Attachment 3

Response to Environment Protection Authority Letter dated 18 December 2019

Development Application No: SSD-7308 Description of Development: St Marys Freight Hub Property Description: Lot 2 Forrester Road, Lots 3 Lee Holm Road and Lot 196 Christie Street, St Marys

Refrigerated Container Noise Levels **ST MARYS freight hub**

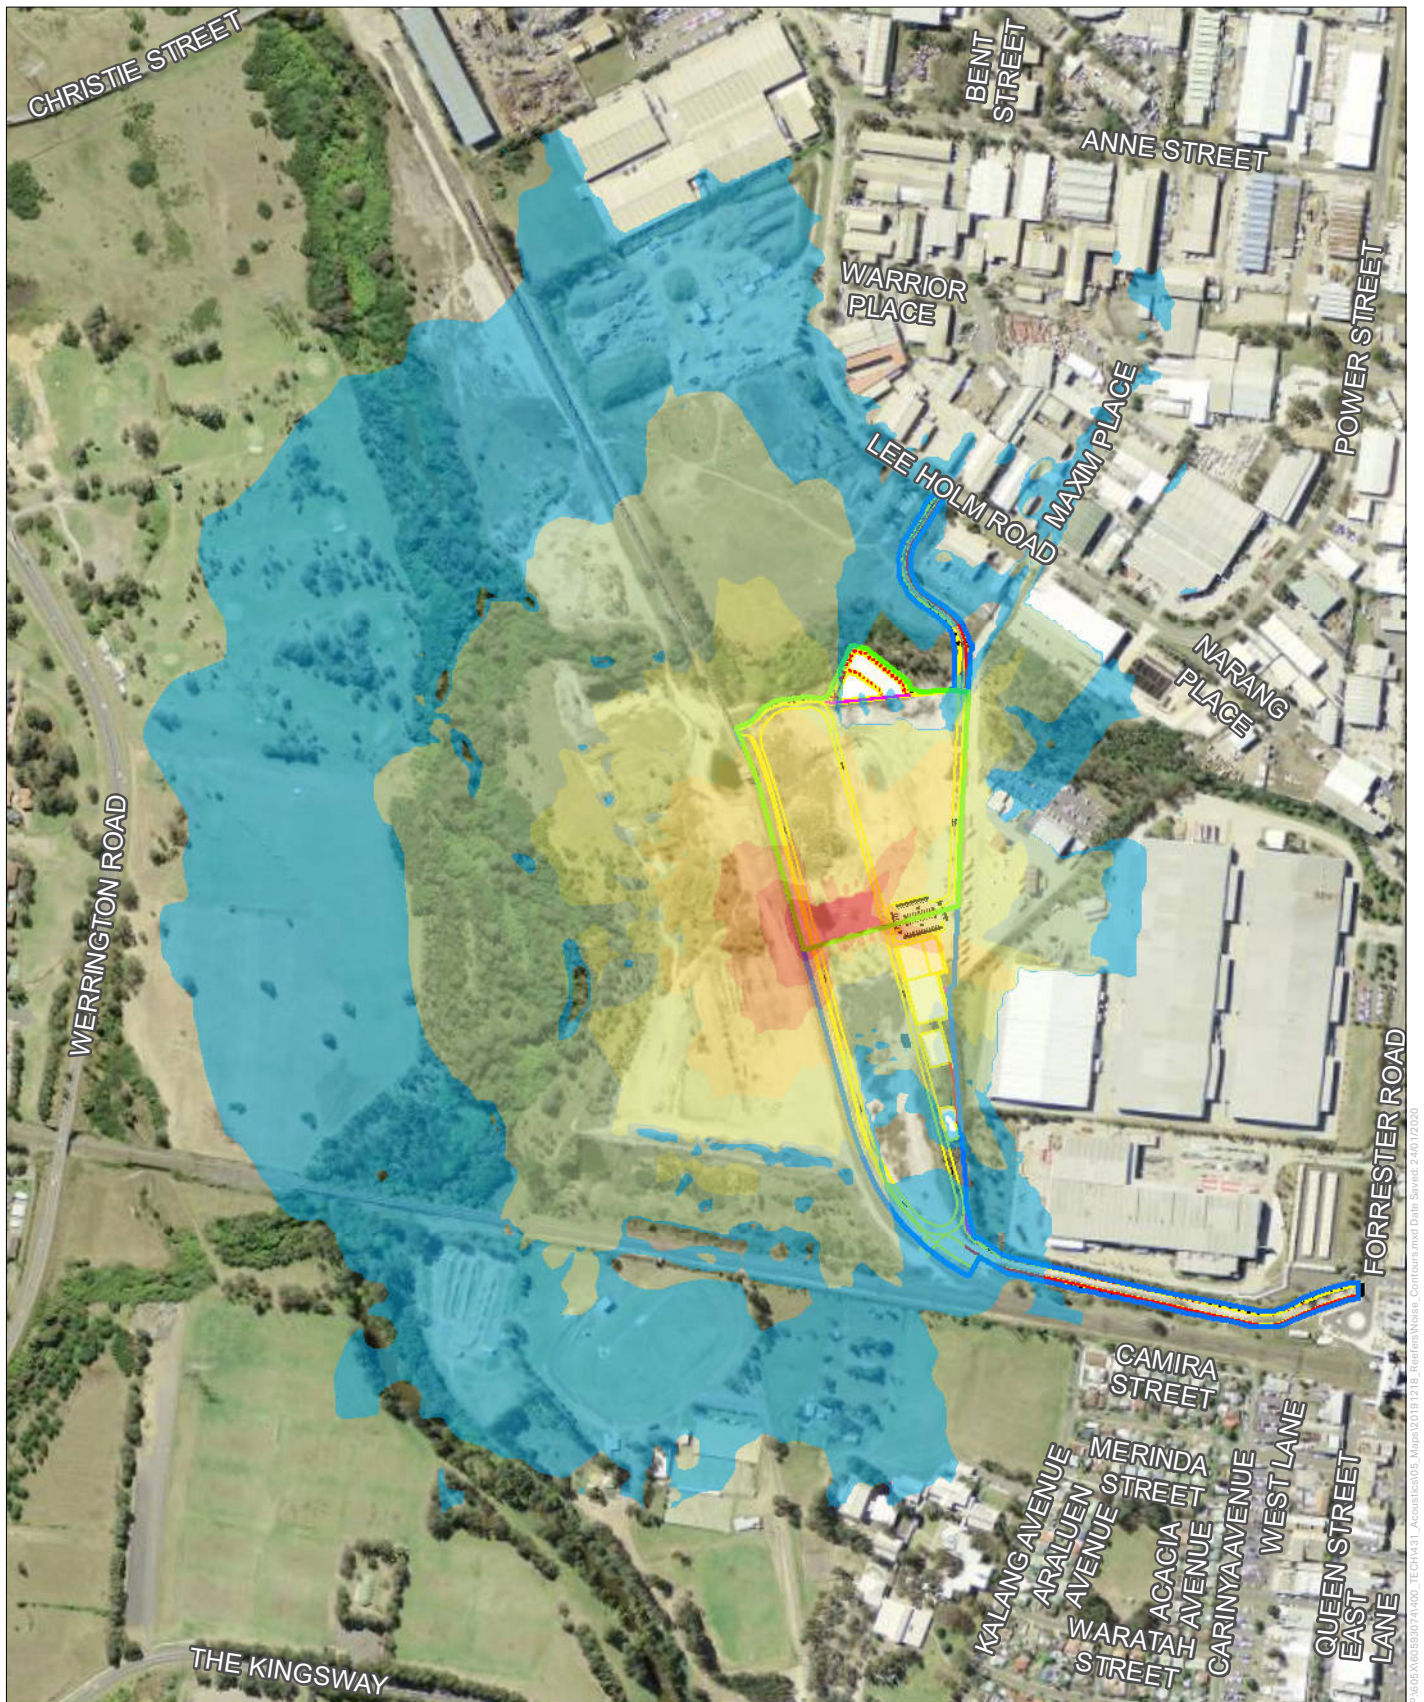
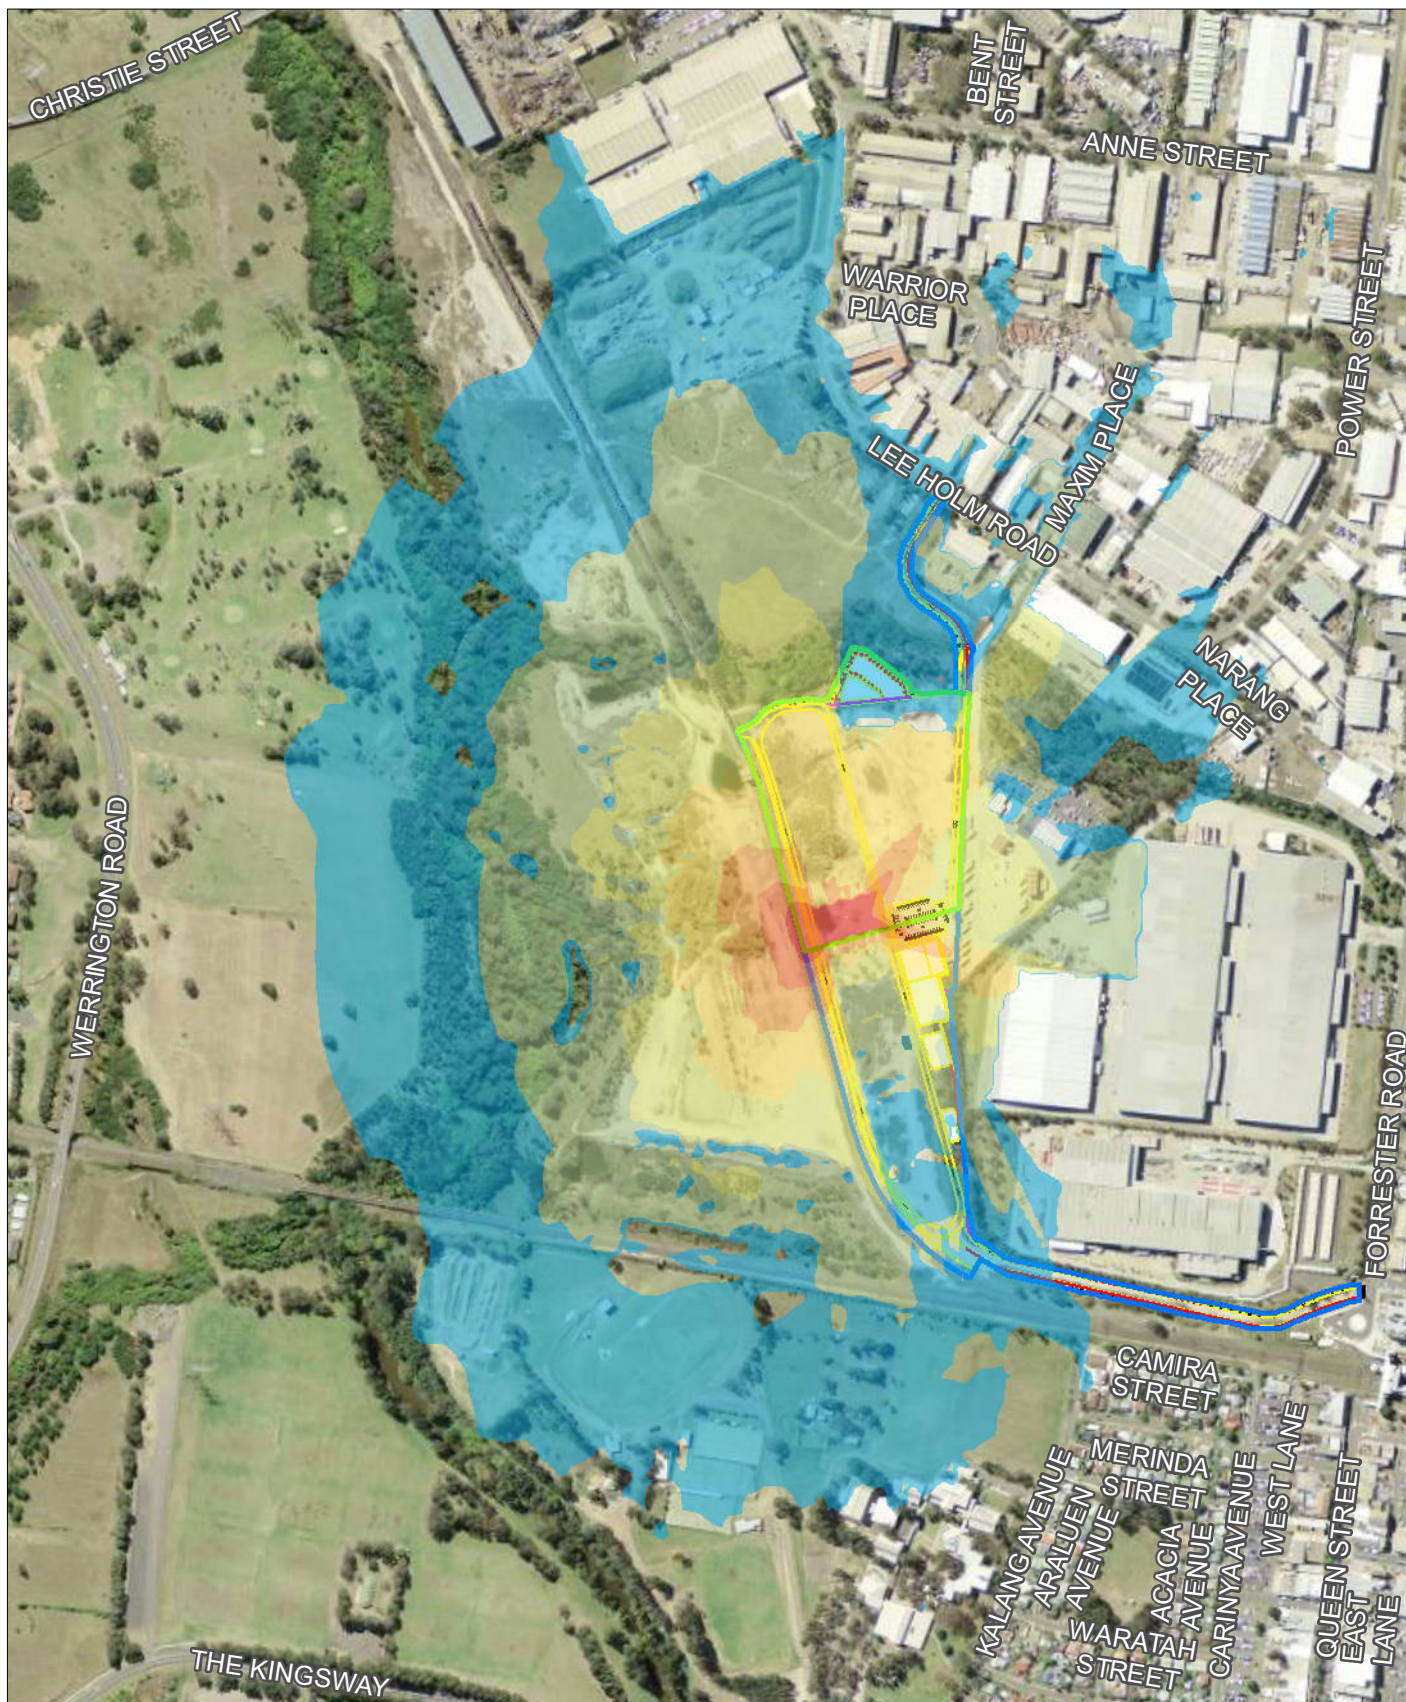
<p>4. The revised layout plans indicate that there could be well over 50 containers with noise producing refrigerated plant located at the closest container storage area to the receivers, which have not been considered in the assessment.</p>	<p>The updated NVIA (enclosed) includes assessment of 50 refrigerated containers, which will be powered by an onsite power source when stacked onsite. AECOM has also modelled and assessed the potential noise impacts from the refrigerated containers and determined an area where there will be no significant noise impact on the closest residential receivers to the south (refer to Appendix E in updated NVIA). The storage area for the refrigerated containers will be located within the area determined to have no noise impact. Accordingly, the refrigerated containers will not have a significant impact on the nearest sensitive receivers.</p>
		<p>5. The RtS noise report has included a correction for impulsiveness, which is not a characteristic assessed in NPfI Fact Sheet C. As previously requested, the applicant should provide an assessment of modifying factors using NPfI Fact Sheet C which includes an assessment of tonal, low frequency and intermittent noise.</p>	<p>The impulsive correction was applied only to door slams and container clangs, which were not the dominant sources for the LAeq assessment, therefore there will be no change in the results. An assessment of the resultant noise levels at receivers for tonality and low frequency noise indicated that no corrections were required to be applied in accordance with the <i>Noise Policy for Industry</i>.</p>
